The Secretary
NSW Department of Planning, Industry & Environment

15 July 2022

I refer to the Department's email of 12 July 2022 regarding the exhibition of the Environmental Impact Statement (EIS), for State Significant Development SSD-11606719 Eastern Creek Recycling Ecology Park Throughput Increase for 'Environmental Impact Statement (EIS) for Eastern Creek Recycling Ecology Park Throughput Increase. Increase in throughput of an existing Recycling Ecology Park from 2 million tonnes of waste per annum (tpa) to 2.95 million tpa, including upgrade of supporting site infrastructure' at 1 Kangaroo Avenue, Eastern Creek (Lots 1-2 DP 1145808, Lot 2 DP 1247691, Lot 7 DP 1200048) in the Blacktown City Council Local Government Area (LGA). Submissions need to be made to the Department by 10 August 2022.

Architectural drawings

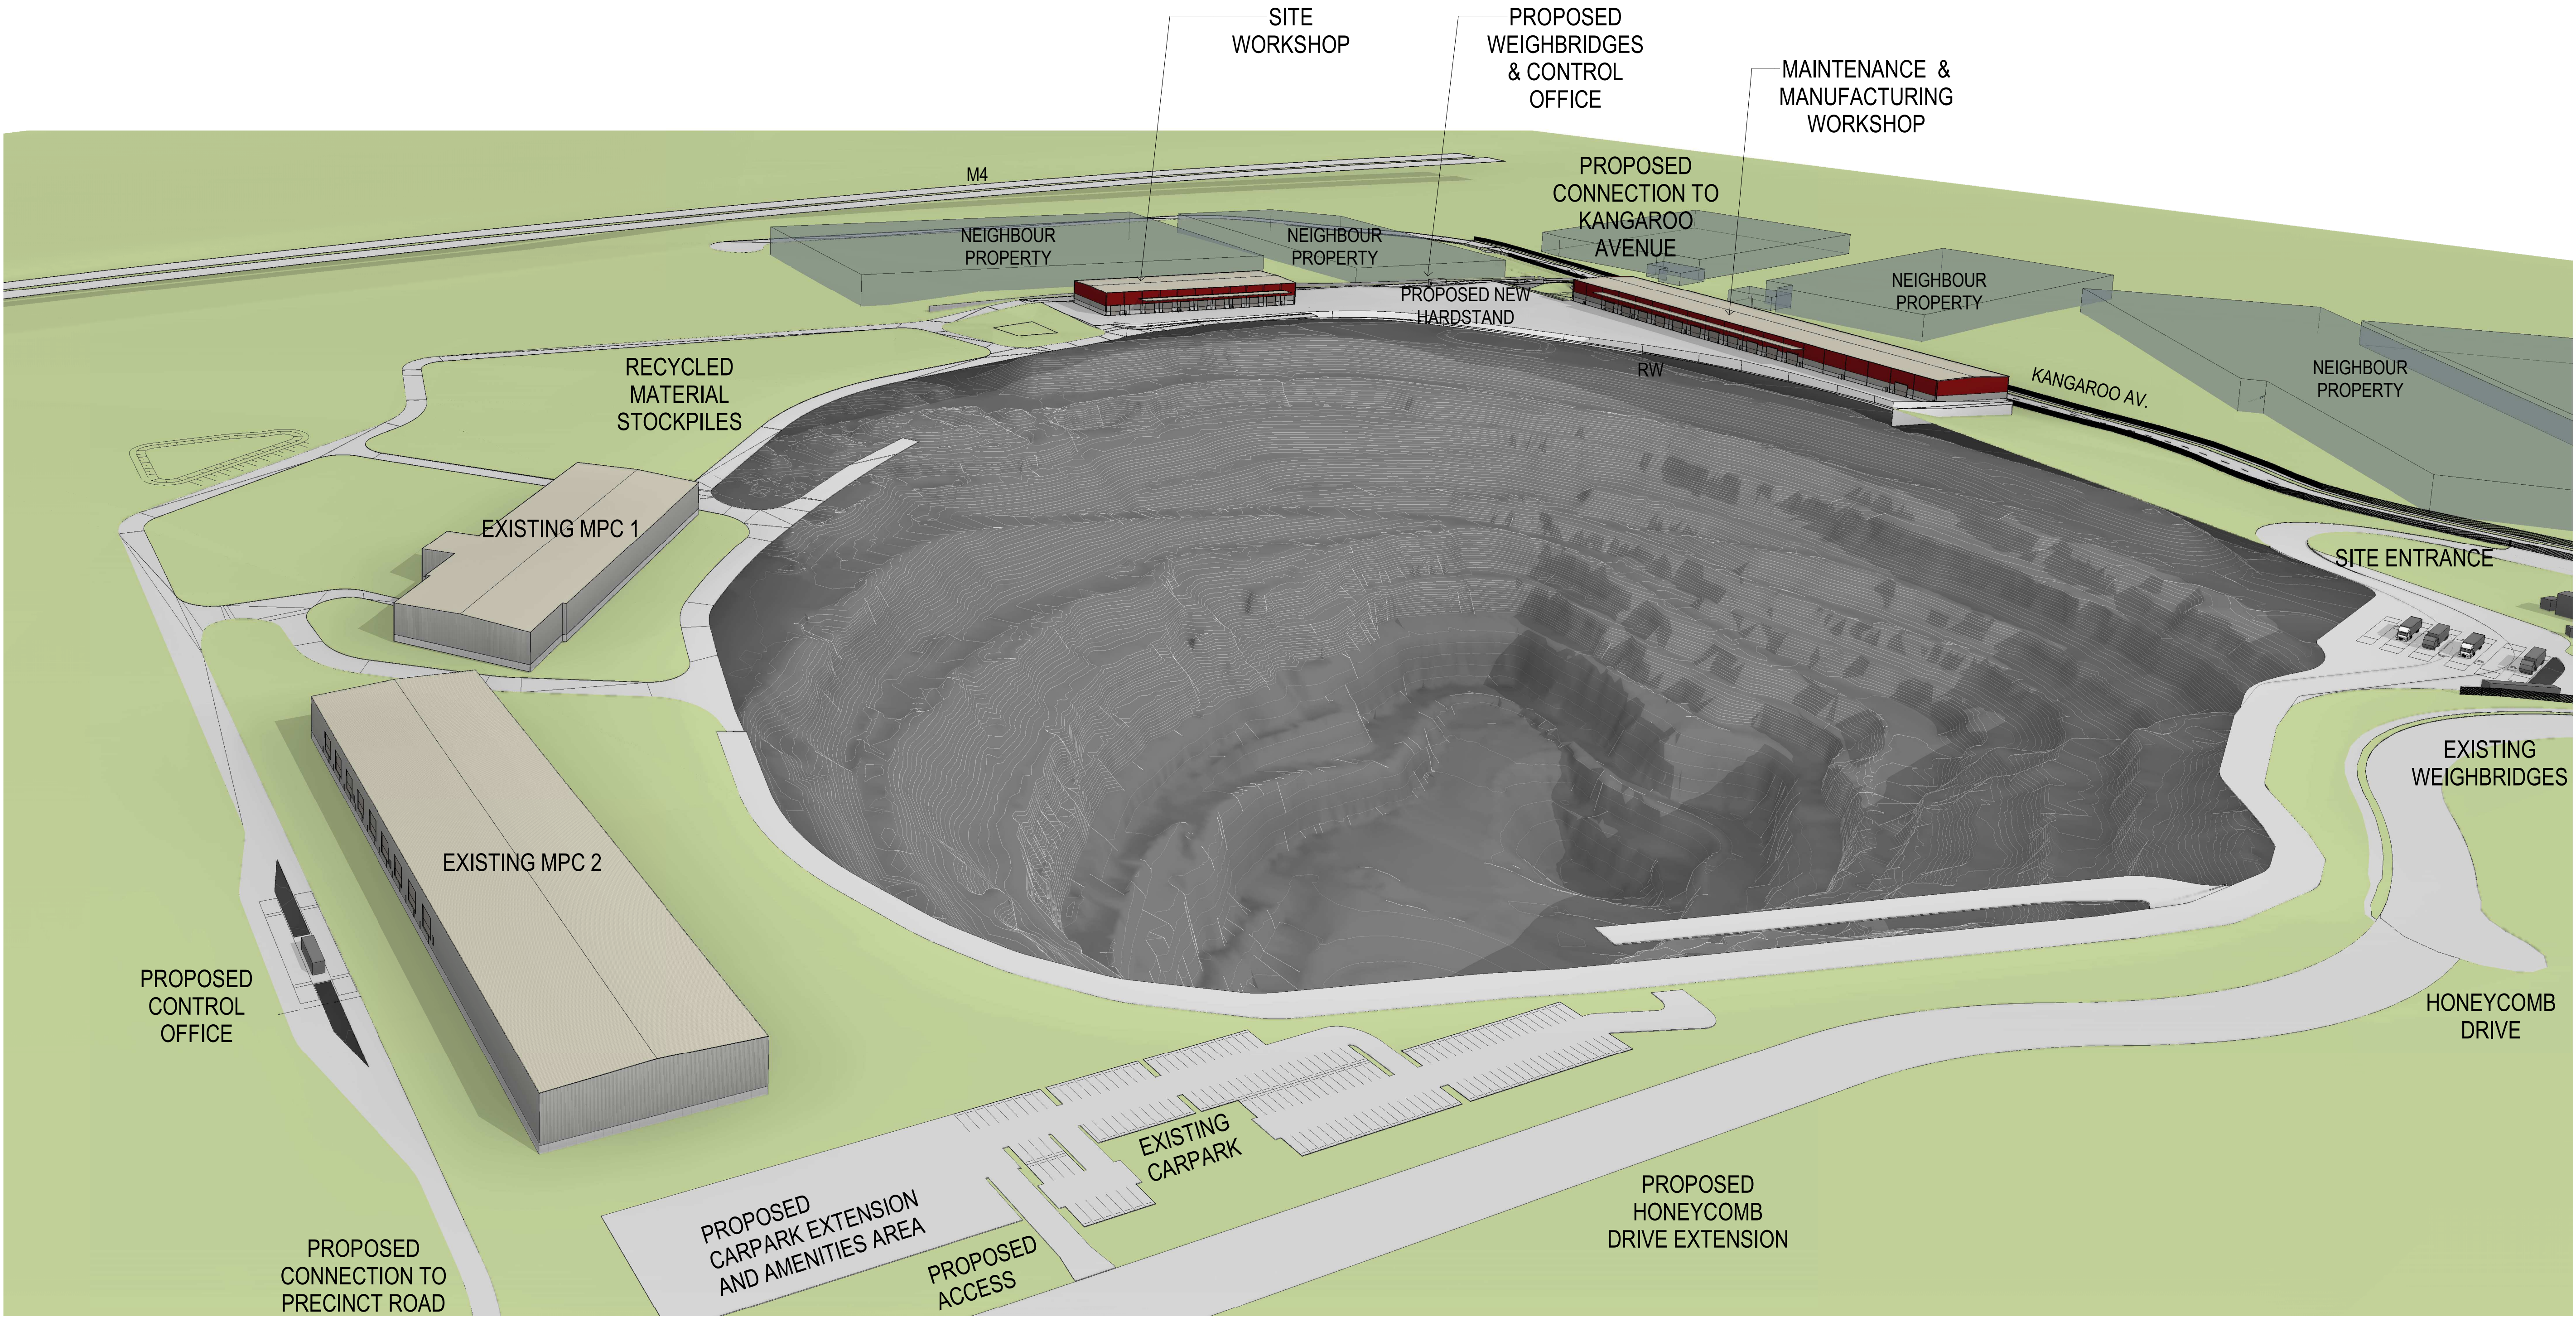
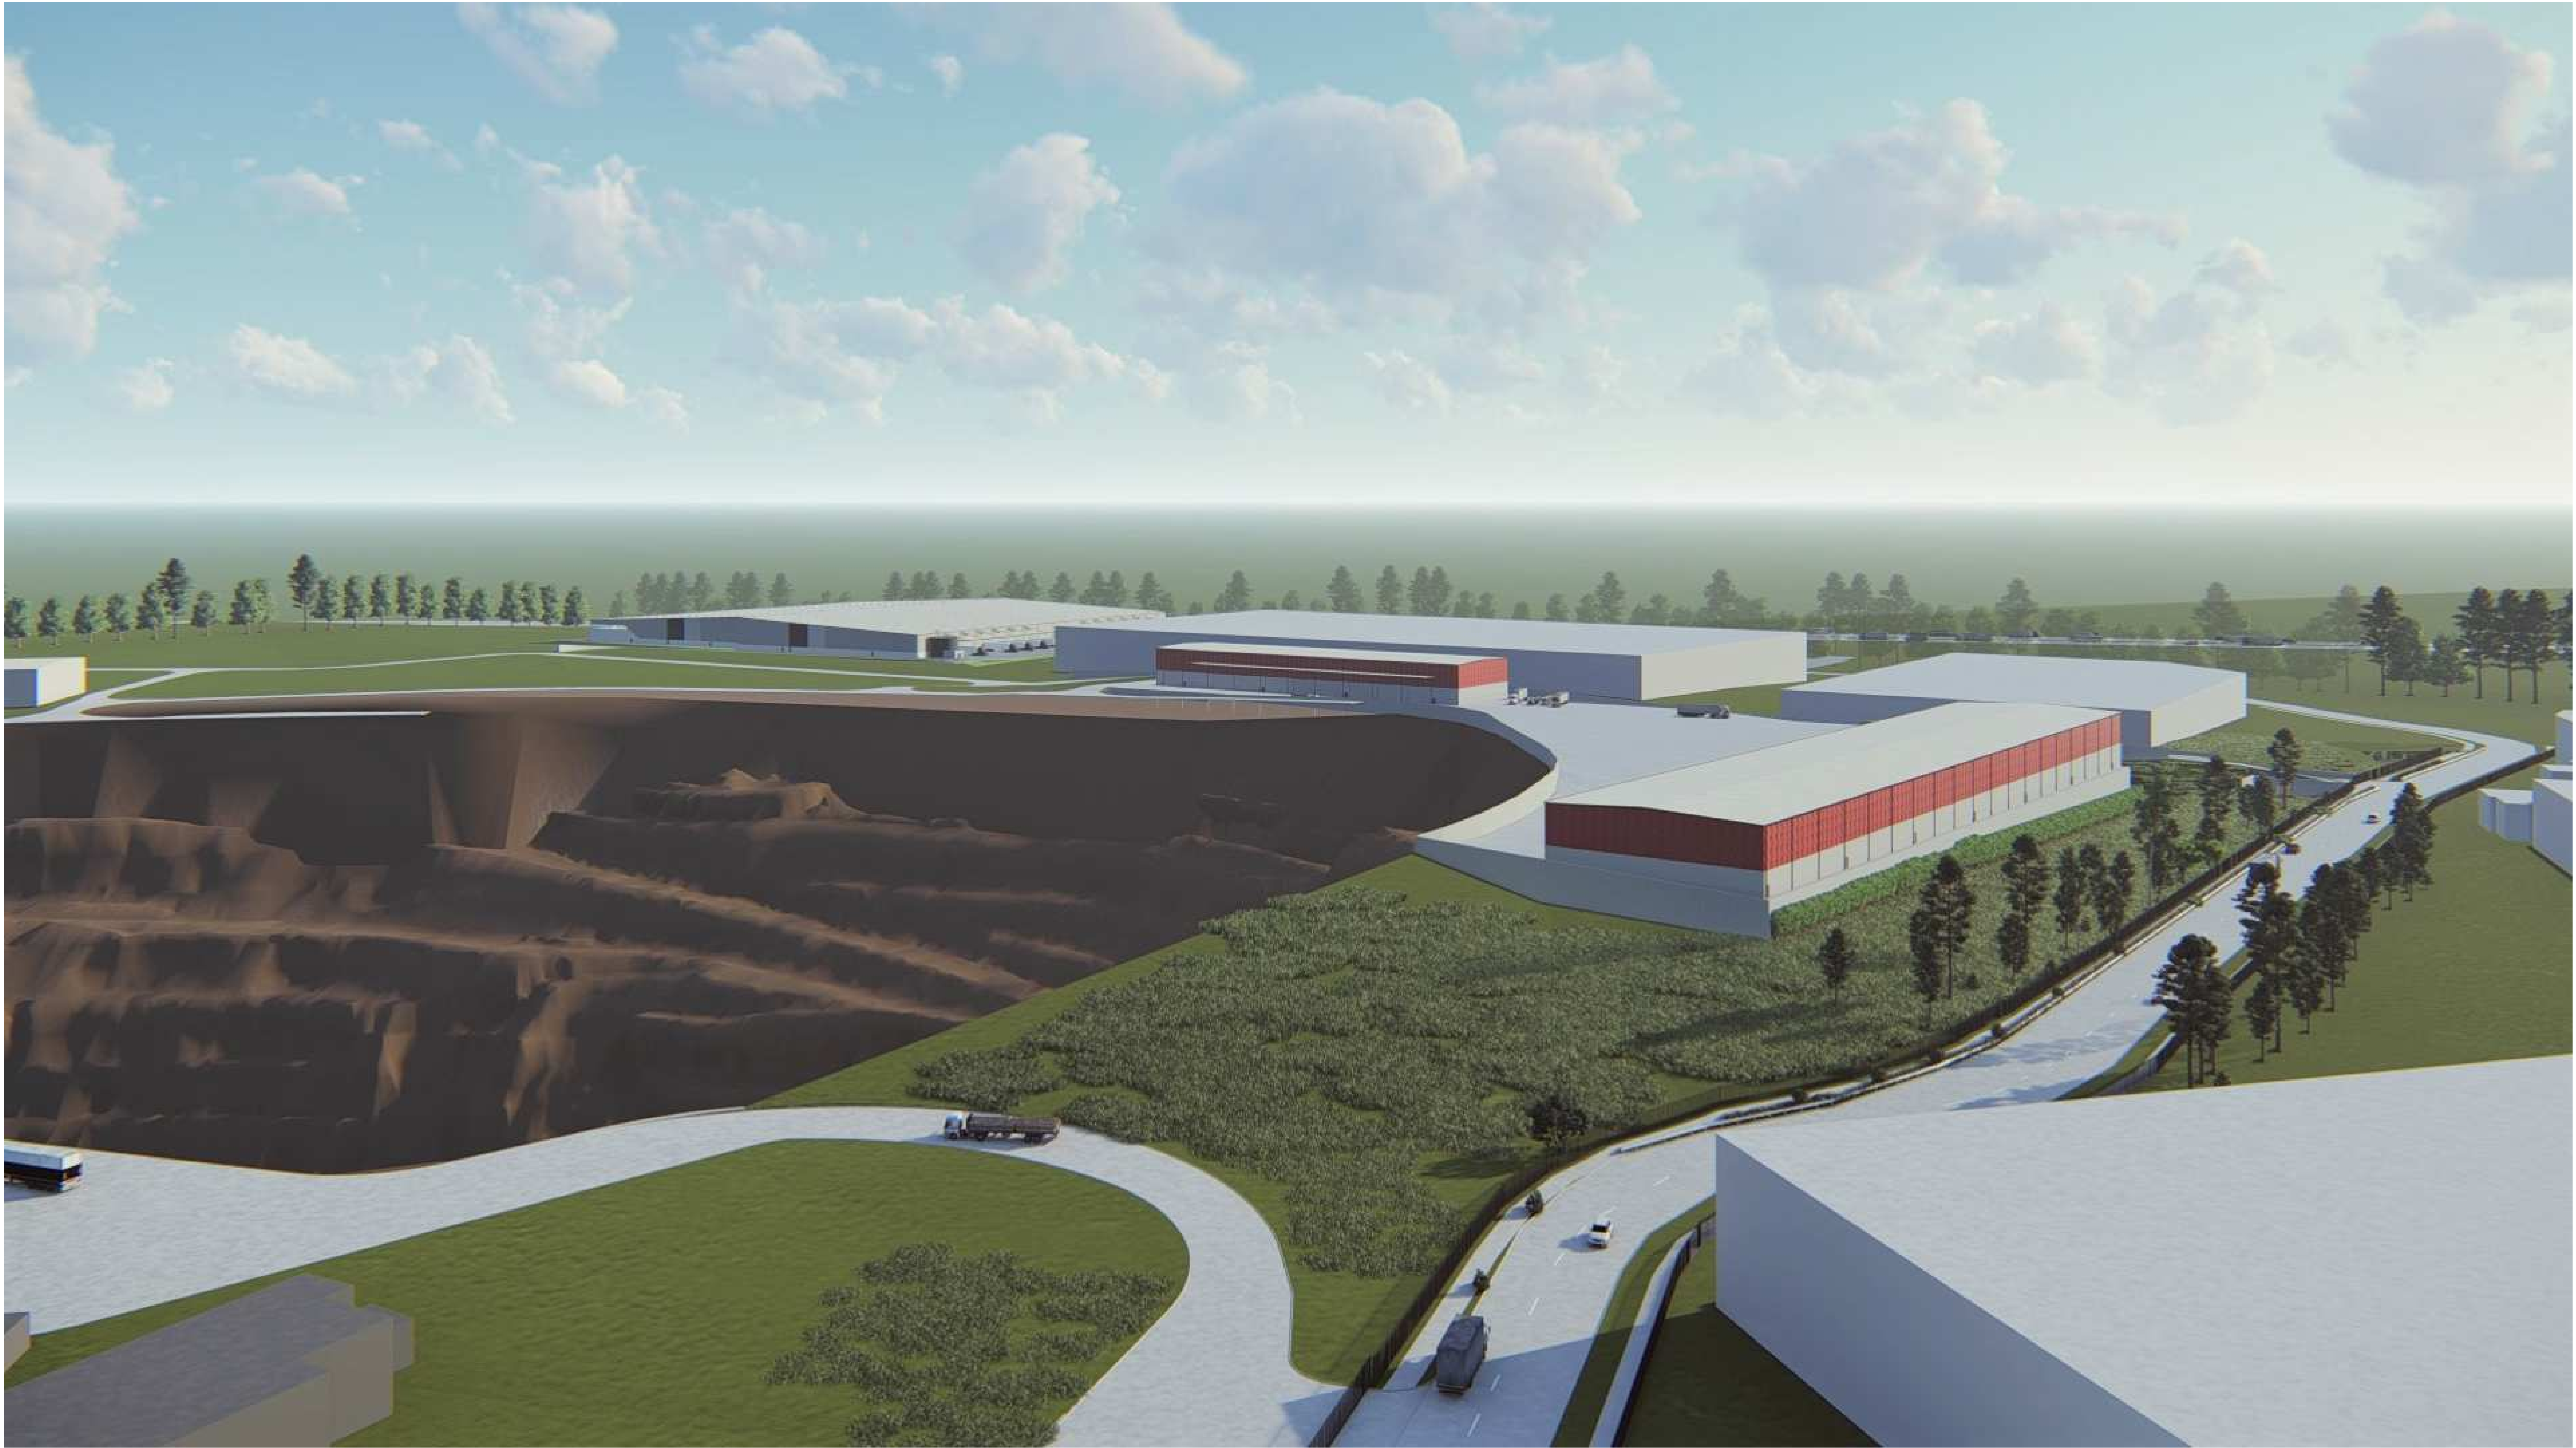
The electrical substations do not appear to be shown in the Architectural Drawings or the Project Visualisations. Any required padmount substation/s will need to be located within the property (in a suitable and accessible location) and be protected (including any associated cabling) by an easement and associated restrictions benefiting and gifted to Endeavour Energy. Please refer to Endeavour Energy's Mains Design Instruction MDI 0044 'Easements and Property Tenure Rights'.

Generally it is the Level 3 Accredited Service Provider's (ASP) responsibility (engaged by the developer) to make sure substation location and design complies with Endeavour Energy's standards the suitability of access, safety clearances, fire ratings, flooding etc.
